October 29, 2021

Subject: Phillips Short Plat/File No. SUB21-004
Response to 06-22-2021 Incomplete Application Comments

PED Project #20014

SHORT PLAT DETAIL  
SEE SHEET 3 OF 4 FOR SURVEY CONTROL  
& EXISTING SITE CONDITIONS

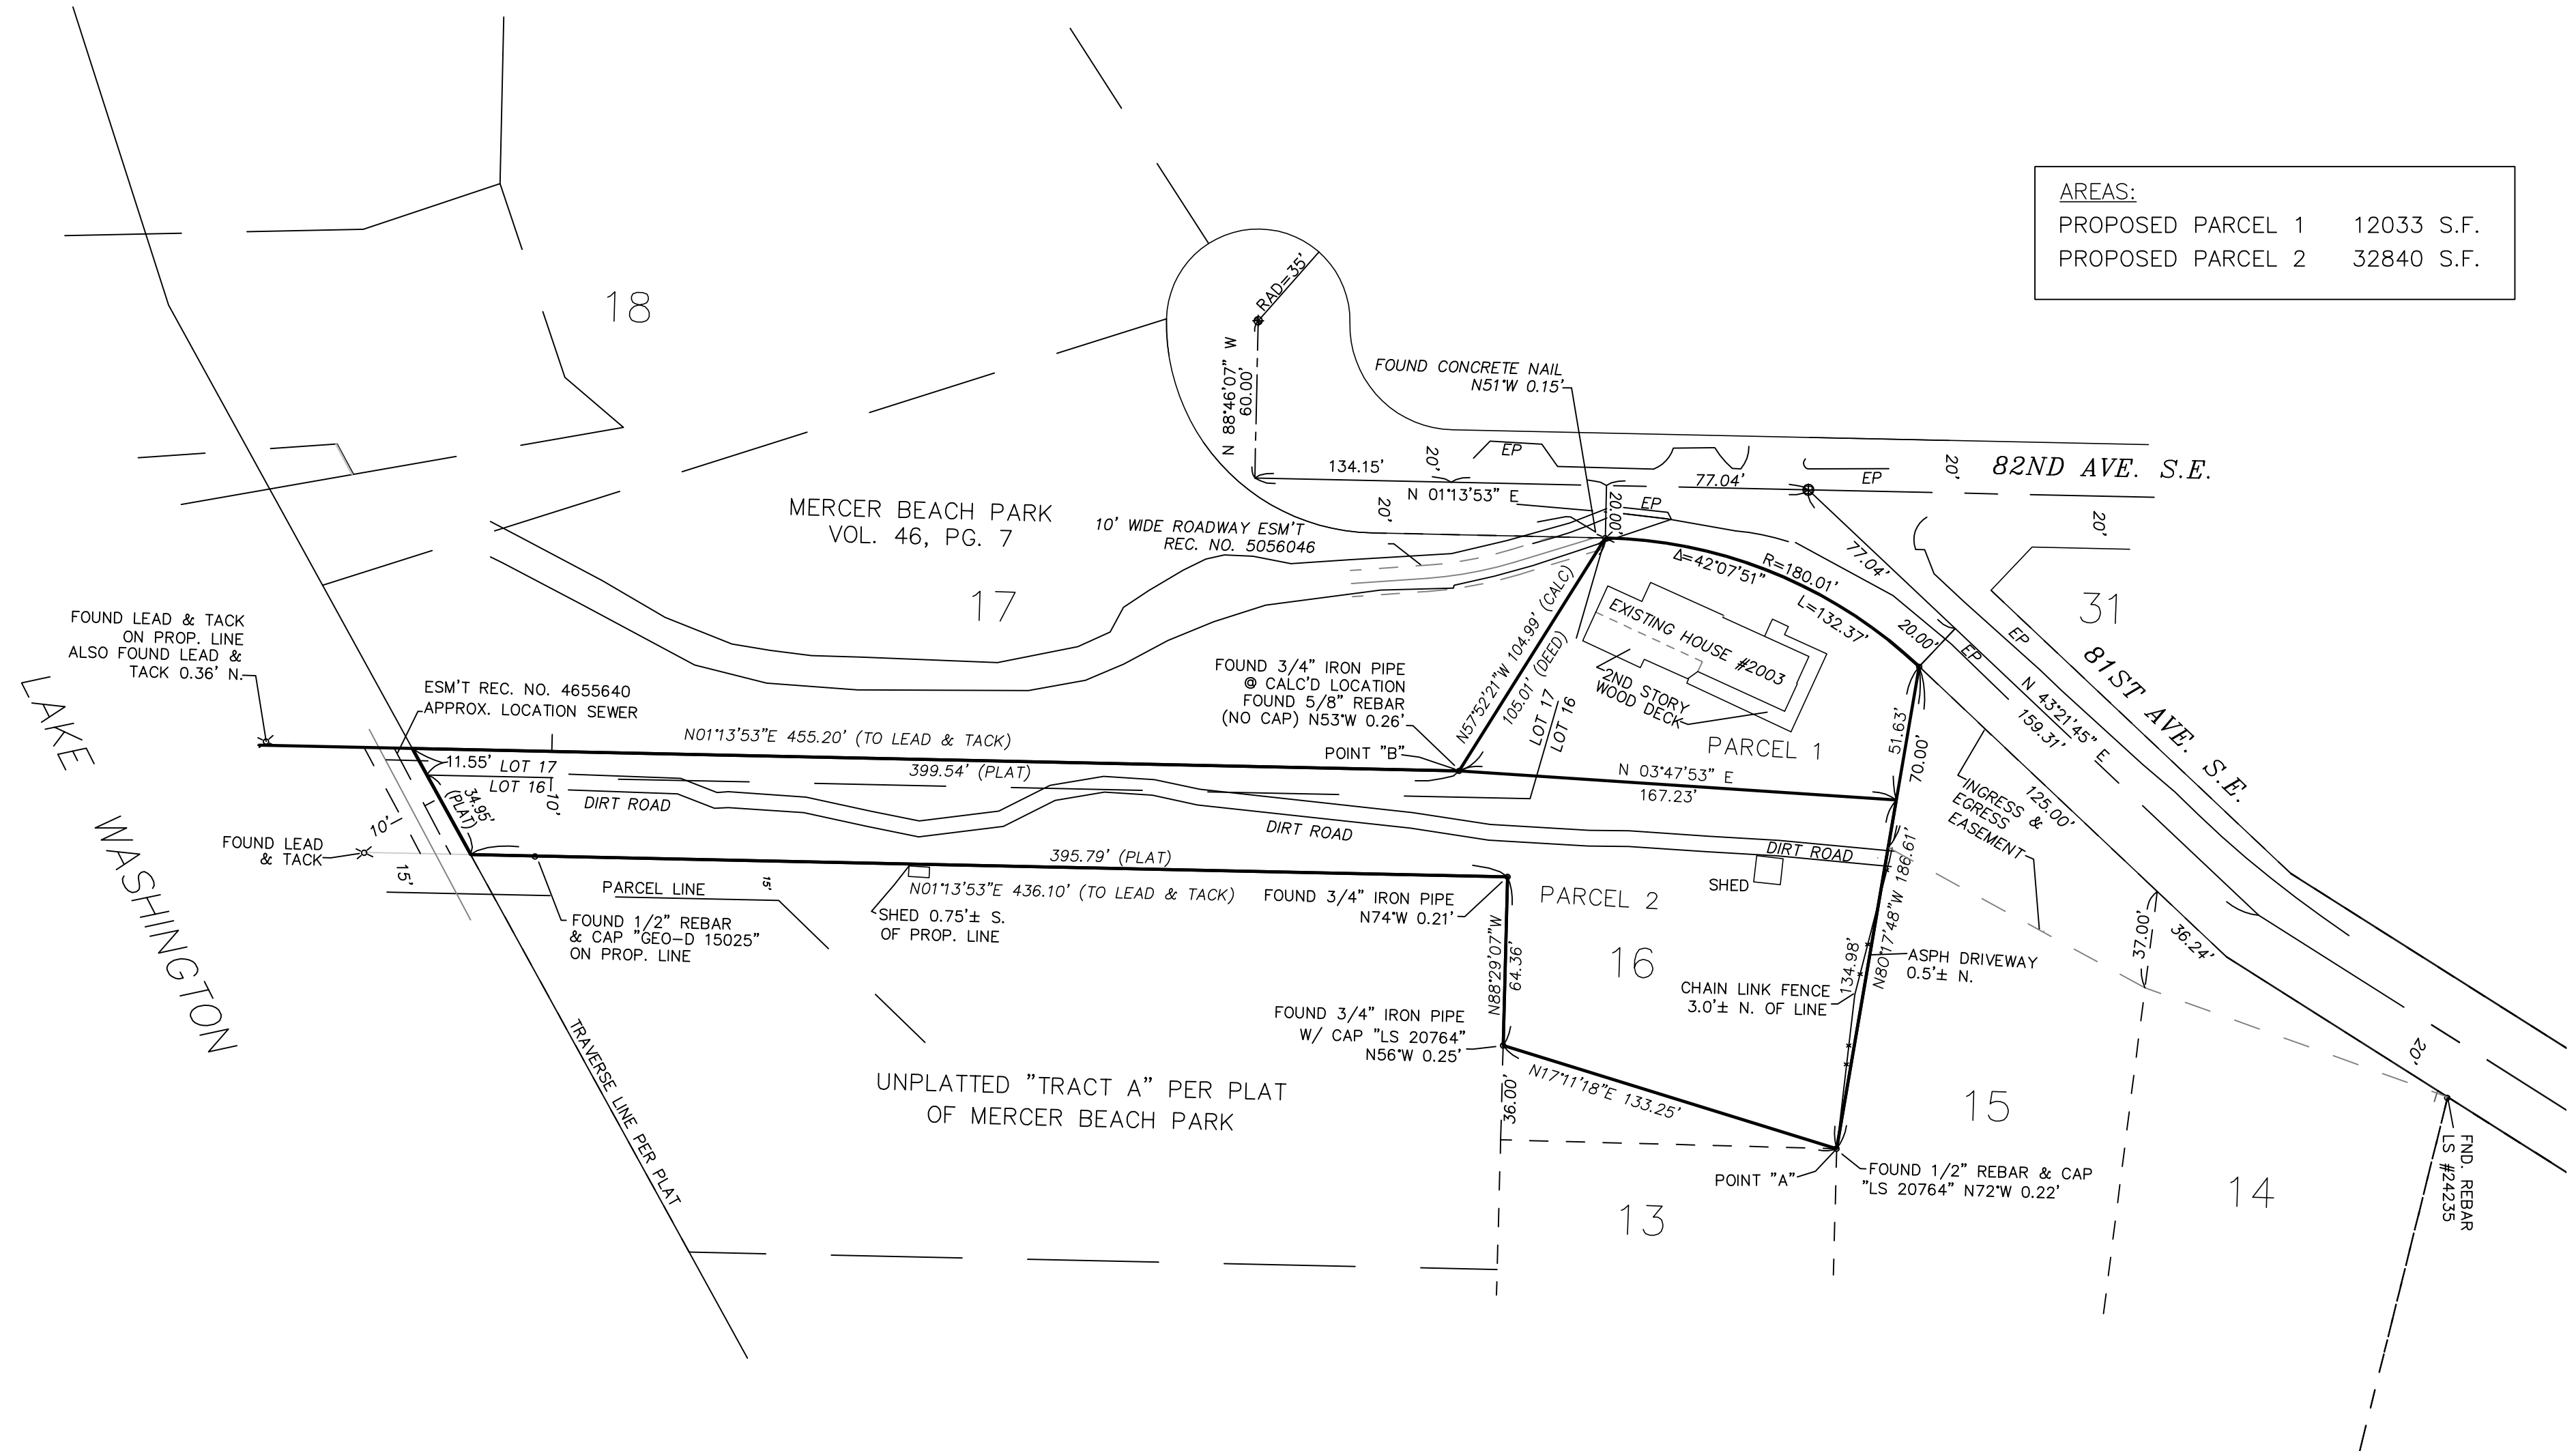
Please also correct the address shown on the site plan. The address is currently listed as "1945 82nd Ave SE," but the correct address is "2003 82nd Ave SE"

Response: See new plan set prepared by Pacific Engineering that addresses these items mentioned above.

**PRELIMINARY TESC  
AND TREE  
RETENTION PLAN  
(NORTH)**

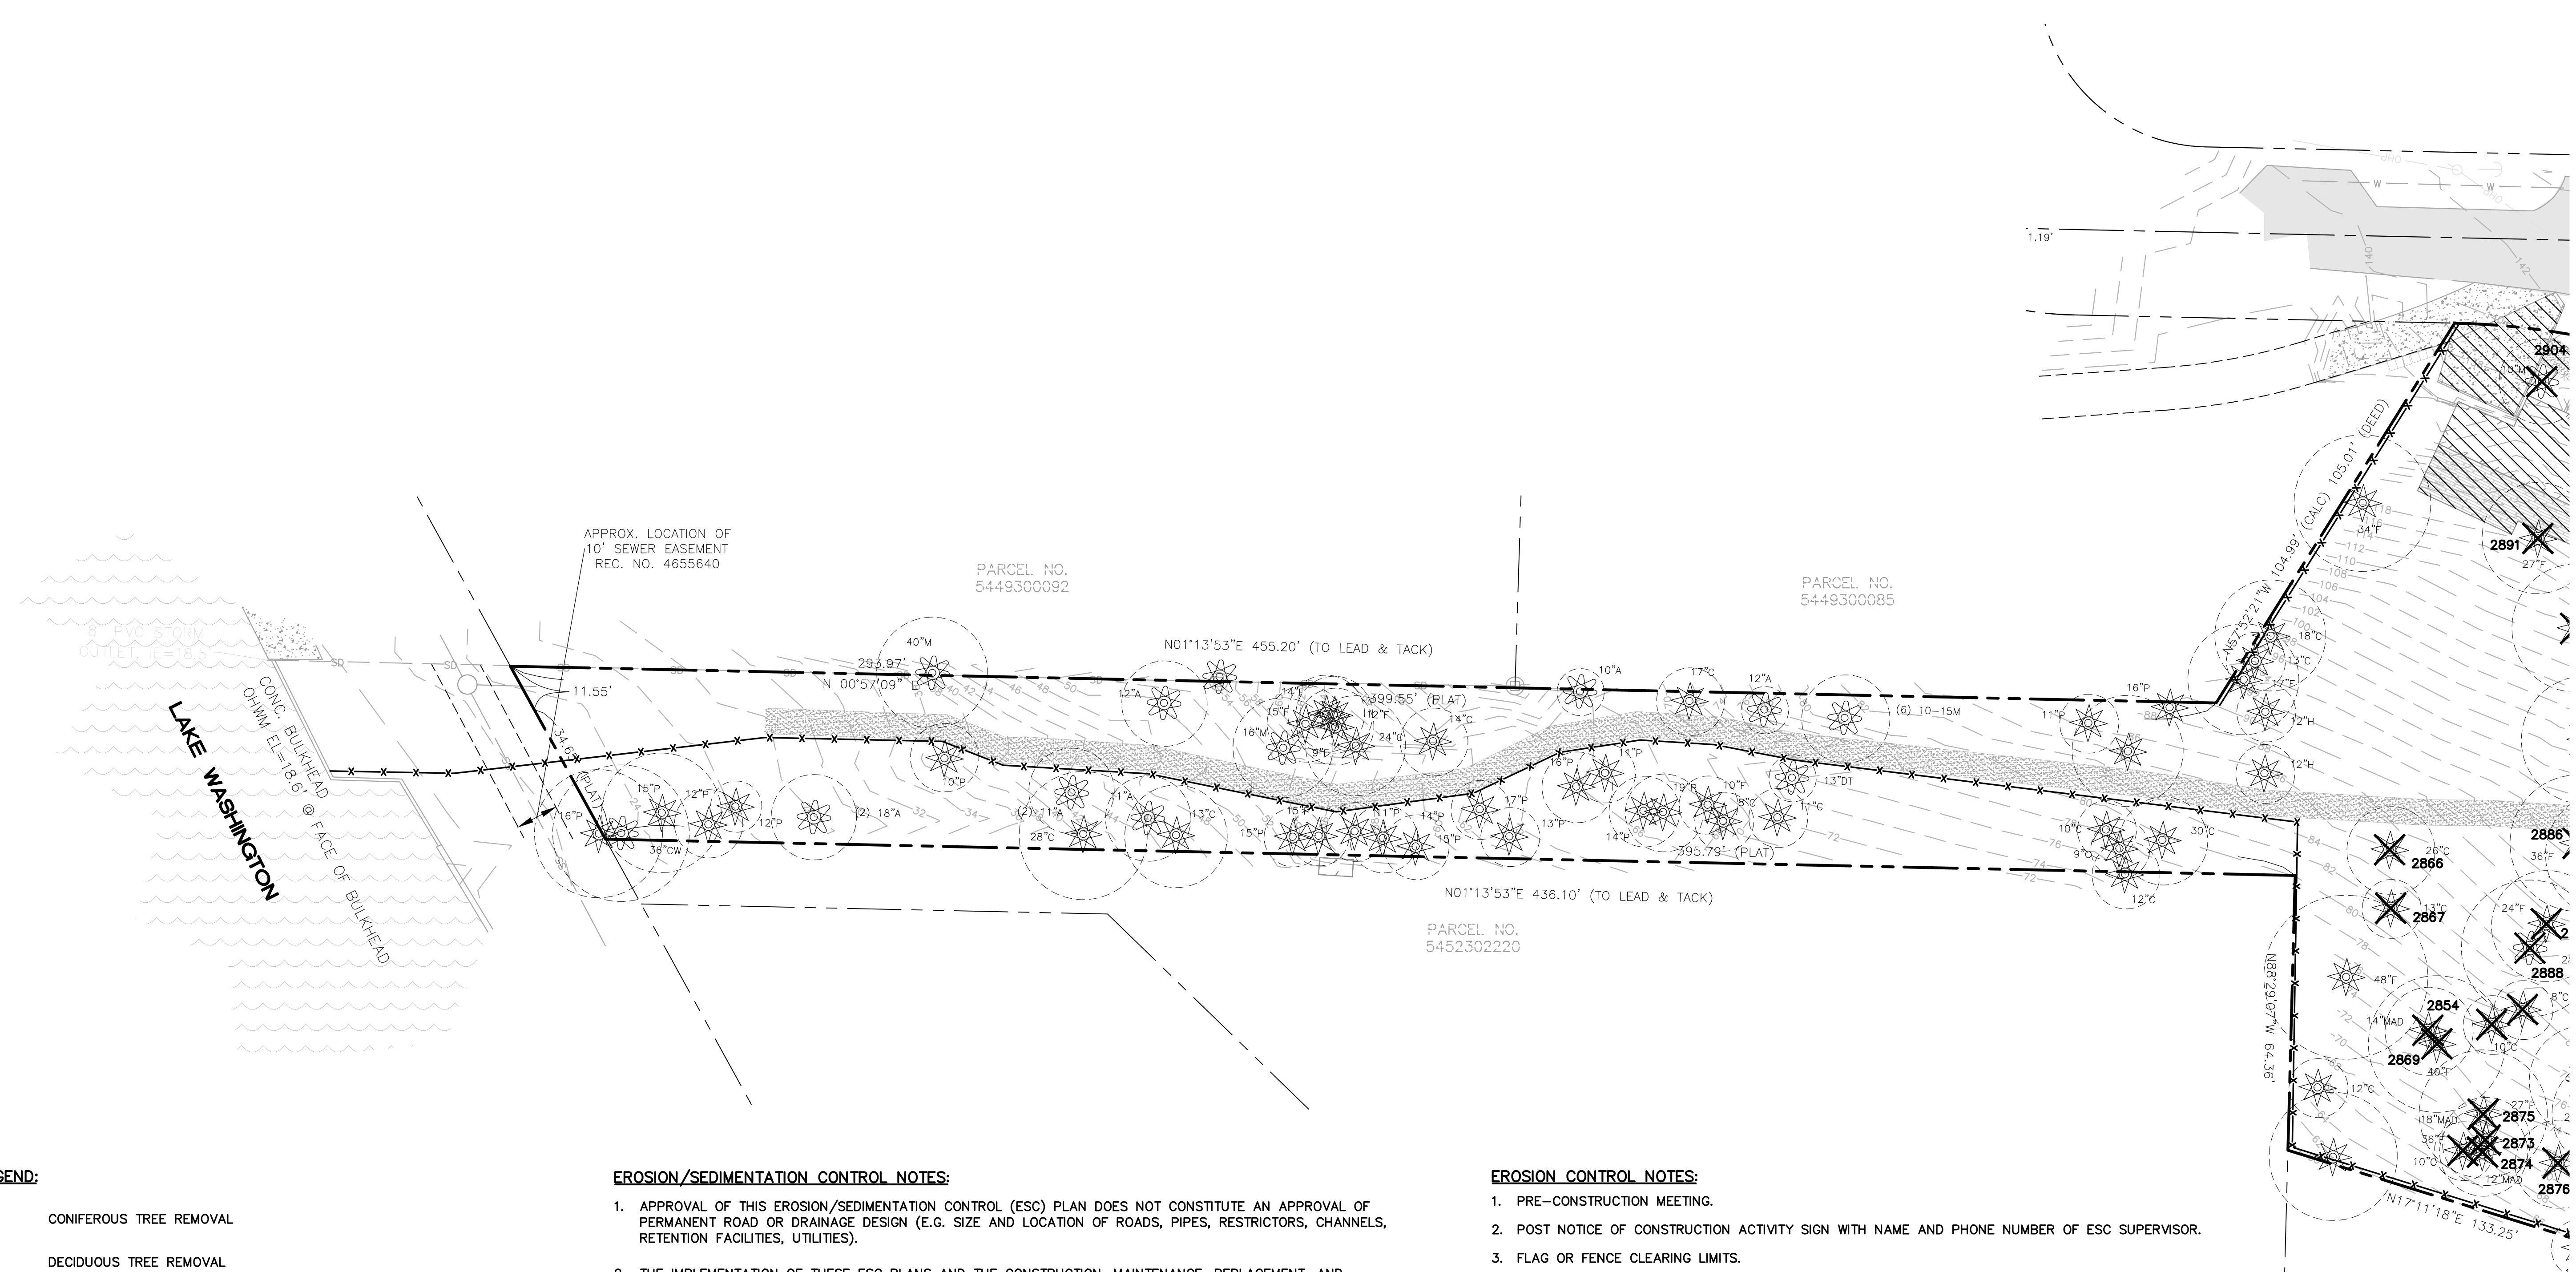
7. *Please provide a tree retention and replanting plan in the development plan set. Please see the attached tree review checklist for more information about needs to be added to the plan set.*

Response: see tree inventory plan included in the Pacific Engineering plan set.

**GRADING AND DRAINAGE PLAN (NORTH)**

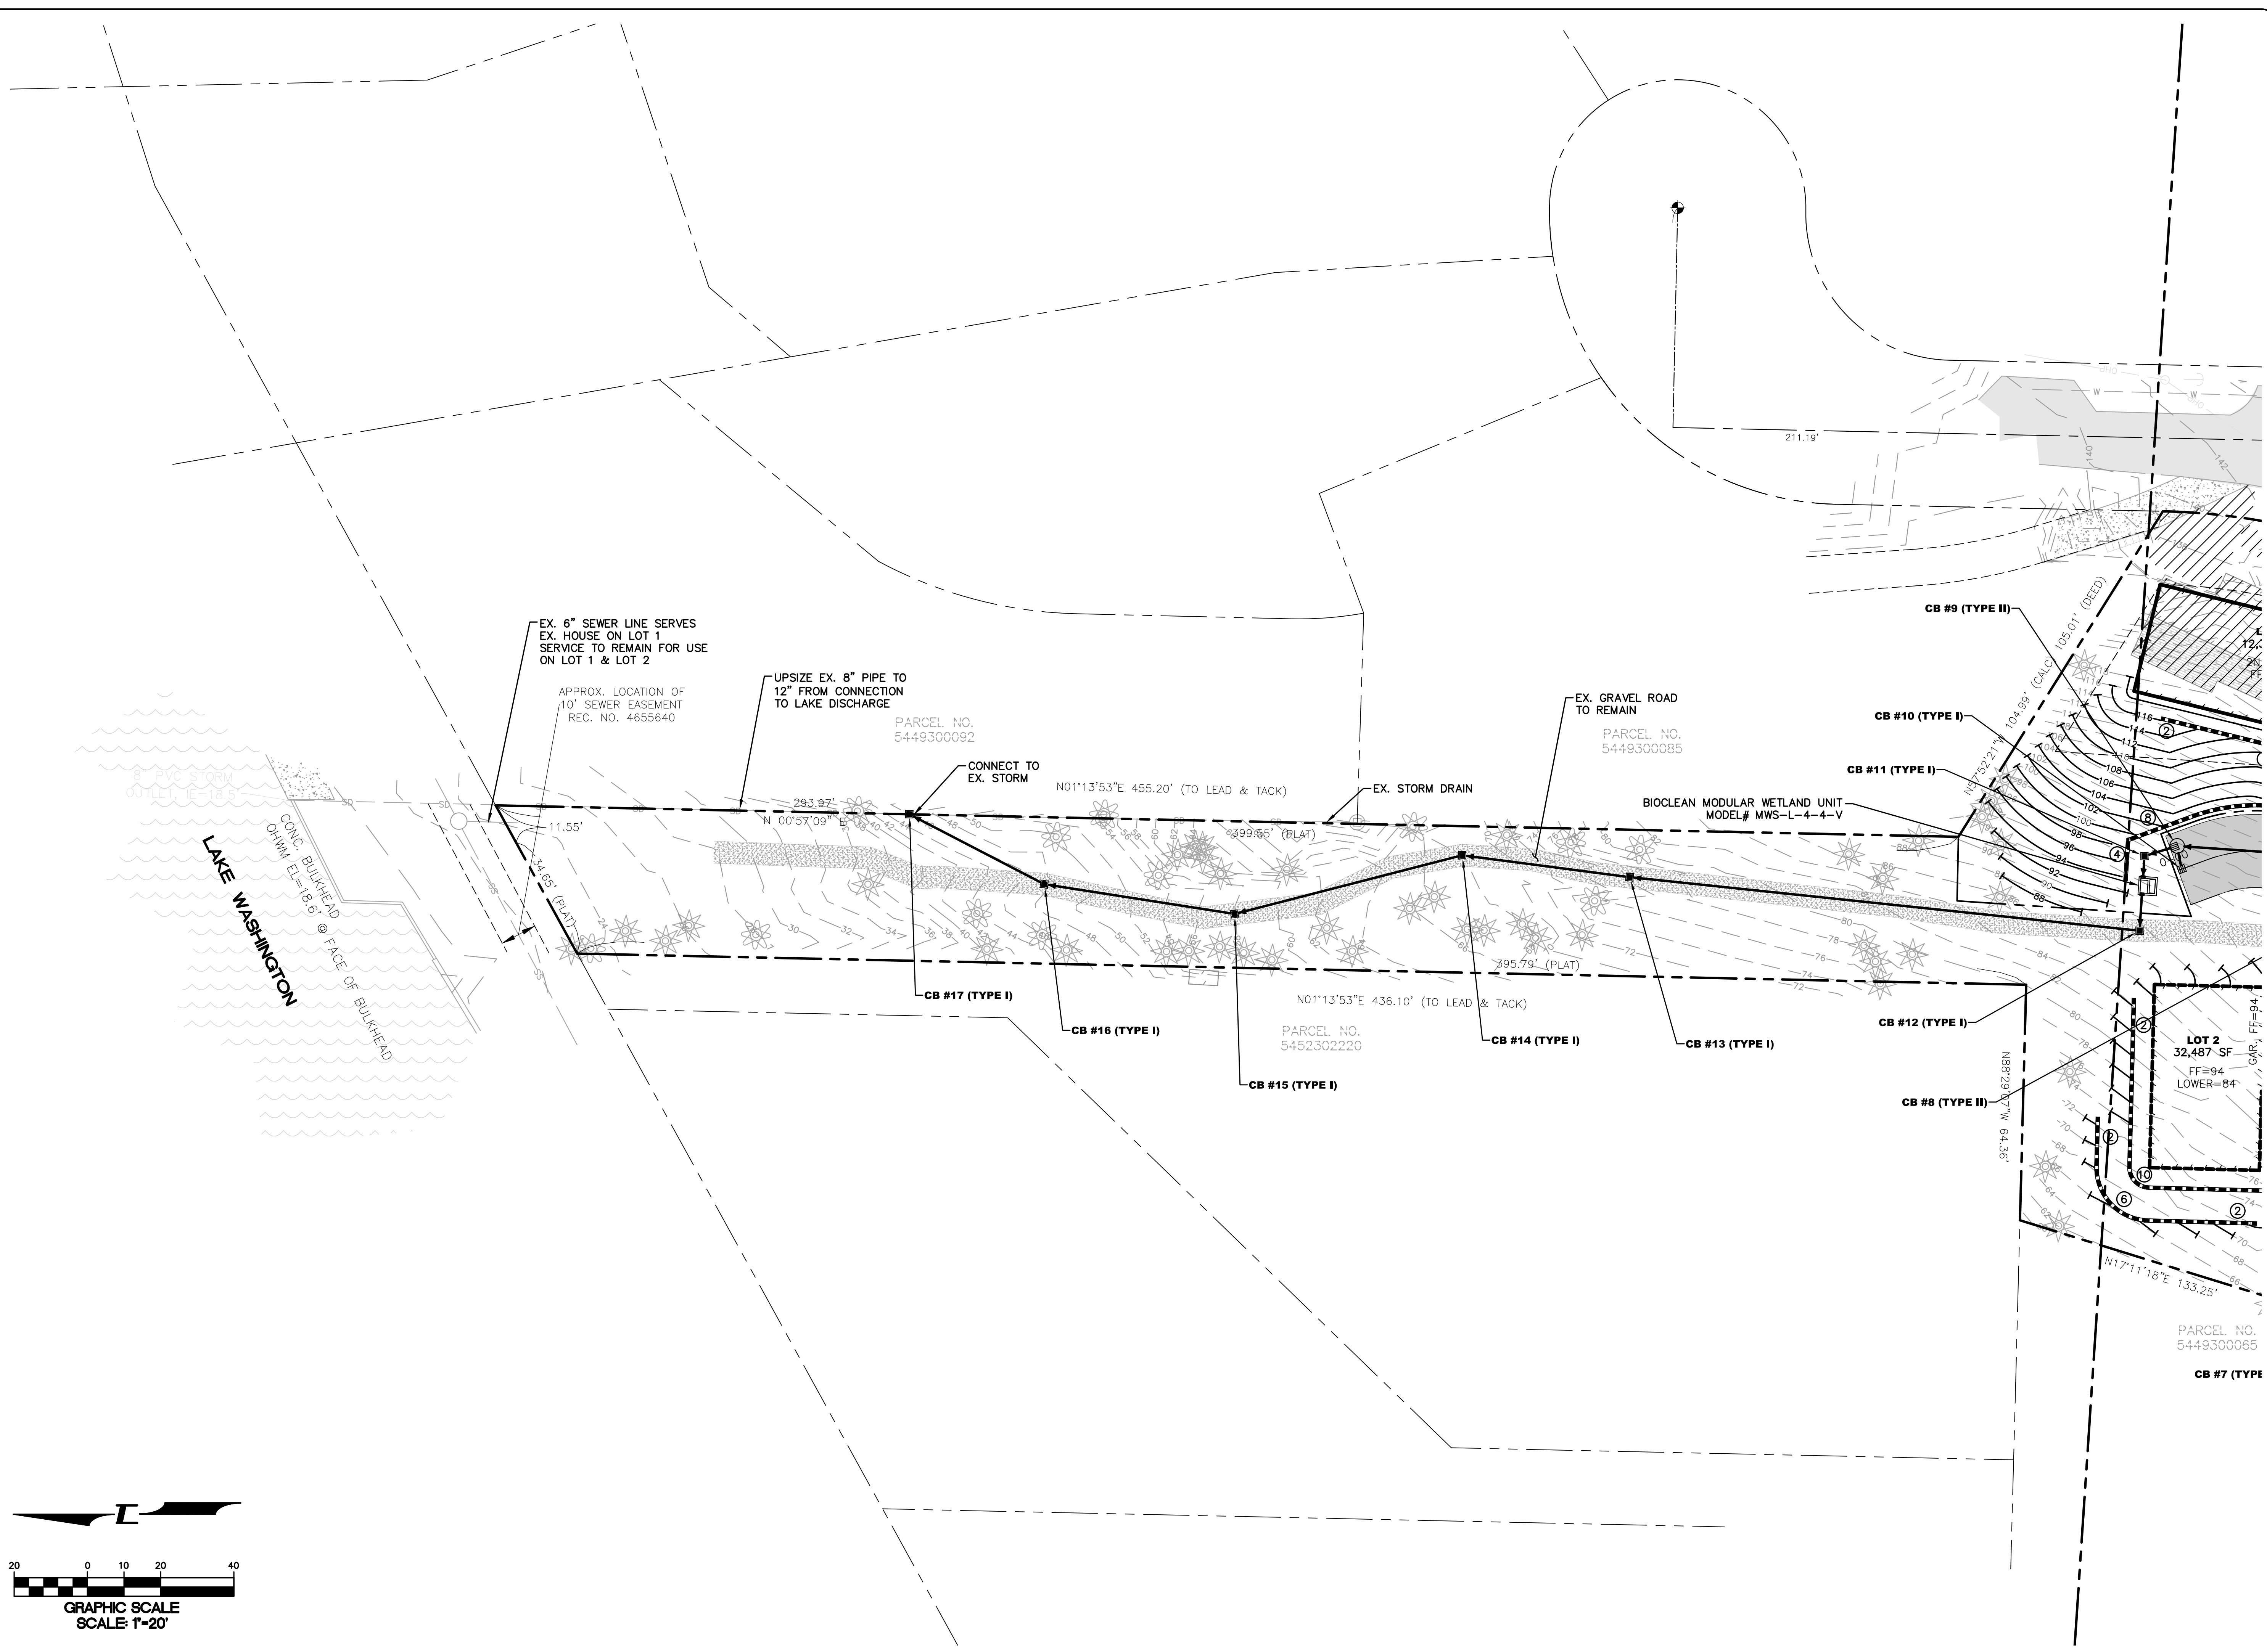
- *Disturbance of the existing, natural topography as a result of anticipated development within the building pad shall be minimized.*
- *Impacts to critical areas and critical area buffers shall be minimized, consistent with the provisions of Chapter 19.07 MICC.*
- *Access to the building pad shall be consistent with the standards contained in MICC 19.09.040.*
- *Building pads shall not be located in:*
 - *Required front, rear, or side yard setbacks.*
 - *Streets or rights-of-way.*
 - *Critical areas, buffer, or critical area setbacks.*
- *No cross-section dimension of a building pad shall be less than 20 feet in width.*
- *All critical areas, including geologically hazardous areas and the top and toe of any slopes in excess of 15%.*
- *A conceptual grading and utility plan*
